| Environmental Health Consultation Response | | Officer | Alan Taylor |
| Detail: Change of use from sui generis to A5 (hot food takeaway) Asian street | | 039199 | |
| Address: | Speed Parlour Chatburn Road Clitheroe Lancashire BB7 2AP | |  <p>Ribble Valley Borough Council www.ribblevalley.gov.uk</p> |
| Application Ref: | 3/2018/0432 | Case Officer: Mr Adam Birkett | |

Sketch

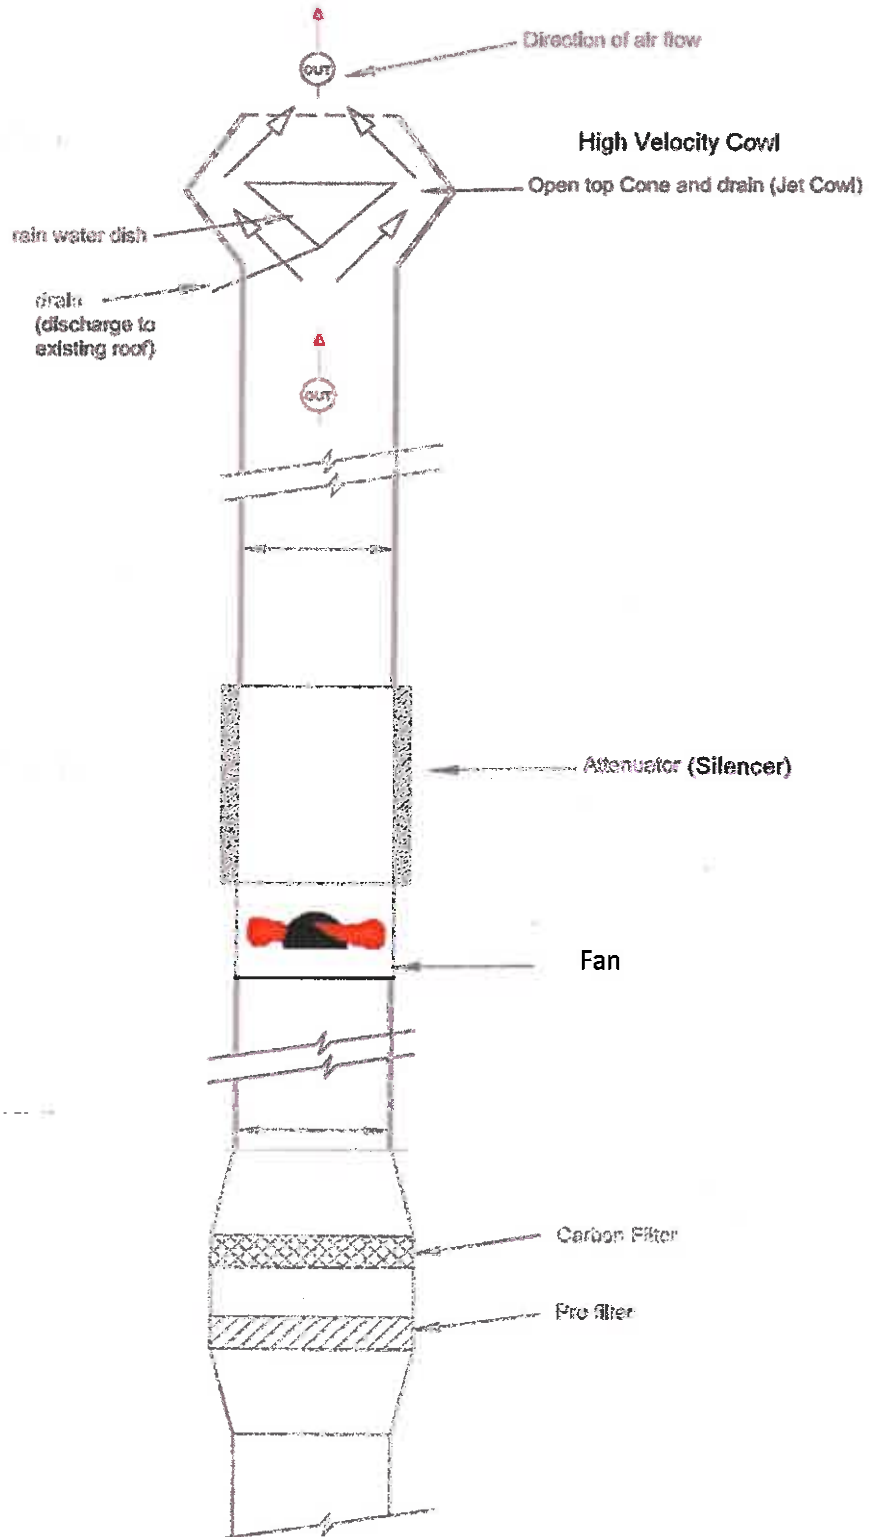
| 2.1 | The application provides a diagram of the extractor system to be installed prior to operation of the takeaway. Page 11 of 14 indicates the Helios Flanged Attenuator RSD/1200 is planned to introduction for noise reduction of the extractor system. The associated list of noise attenuation fails to identify the specific attenuator but provides a list of noise levels attained by similar attenuators. Should these be of a similar characteristic then there should no noise to consider outside of the boundary of the application site to affect neighbouring properties. | | |
| 2.2 | Odour nuisance should be controlled through frequent cleaning of the extractor system and replacement of the filters located within the airflow of the extractor. | | |

| | <ul style="list-style-type: none"> Any noise generated from the extractor system should not be heard beyond the boundary of the application site. No odours to be witnessed beyond the boundary of the planned application site. | | |
